**M25 junction 10/A3 Wisley interchange
TR010030**

**9.51 Applicant's comments on
Royal Horticultural Society's
Deadline 3 submission**

February 2020

Regulation Number:	8 (1)(c)(i)
Planning Inspectorate Scheme Reference	TR010030
Application Document Reference	TR010030/EXAM/9.51
Author:	M25 junction 10/A3 Wisley interchange project team, Highways England and Atkins

Figure 1: Wisley & Ockham Commons Management Plan 2010 – 2020 management prescriptions for woodland clearing / felling shown with the 150m buffer zone from the roads

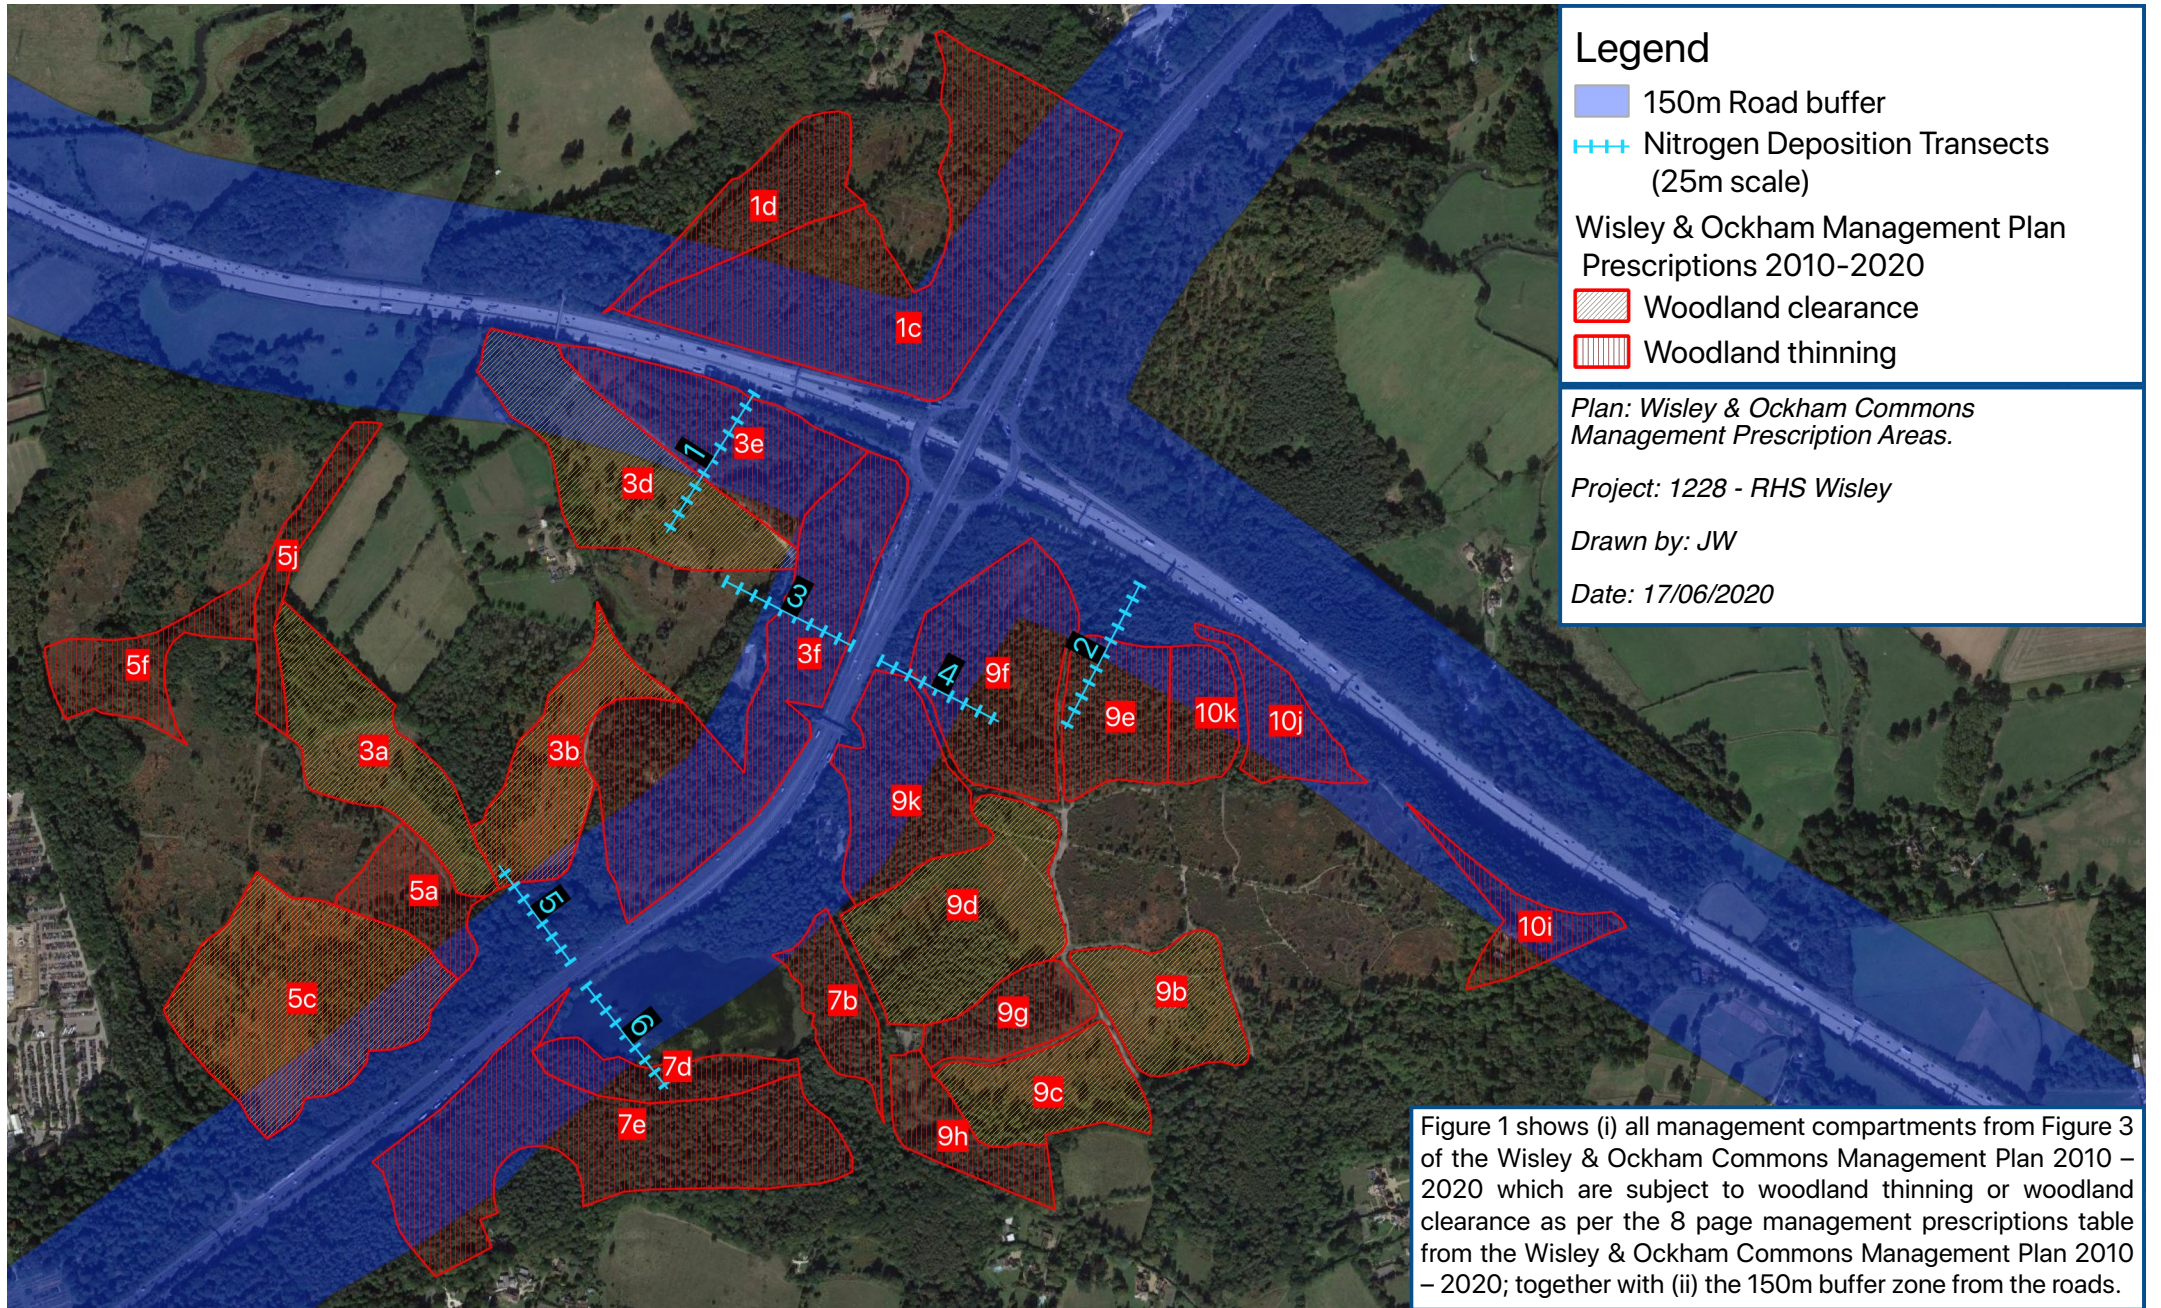
RHS Letter Reference	Issue	Highways England Response
		<p>heathland habitats occur at a distance of 150 m or greater, and therefore, any points closer than 150 m fall within the woodland buffer. Refer to Figure 7.2 of the Biodiversity figures [AS-013] for a plan of the woodland within the SPA.</p> <p>As has been recorded in Habitats Regulations Assessment Annex B [APP-041], in Item 4.0 of the meeting held on the 16th March 2018, the Surrey Wildlife Trust has confirmed that the intention of the current management plan for the Ockham and Wisley Commons SSSI component of the SPA is to maintain existing areas of heathland, rather than creating new areas of heathland by removing additional areas of the coniferous woodland buffer. Natural England confirmed this again by email on the 31st January 2020 - 'The current management plan for Ockham and Wisley Commons SSSI produced by Surrey Wildlife Trust, which Natural England has endorsed, is primarily focussed on the maintenance of the current areas of open heathland, and in particular the enhancement of the quality of the habitat so that it meets the basic objectives set by Natural England, so that the feature can be described as being in a 'favourable' condition. The current Countryside Stewardship agreement between Natural England and Surrey Wildlife Trust, which runs for 10 years, is also focussed on the management of the existing open heathland resource. It does not seek to extend the open heathland area through the felling of mature trees. Therefore, Highways England can confirm with a high degree of confidence that the removal of conifer trees to extend the open heathland is not part of the current management of the site or required to achieve Favourable Conservation Status.</p> <p>The suite of compensatory measures will include the removal of mature conifer trees within the site and the restoration of heathland, and as confirmed in 3.2.1.6 of Natural England's written representation [RR-020], this is additional to the existing management plans. The SPA management and monitoring plan [AS-015] includes 15 years of management and monitoring for the heathland restoration habitats, and this will enable the monitoring party and the steering group to respond accordingly should the areas in close</p>
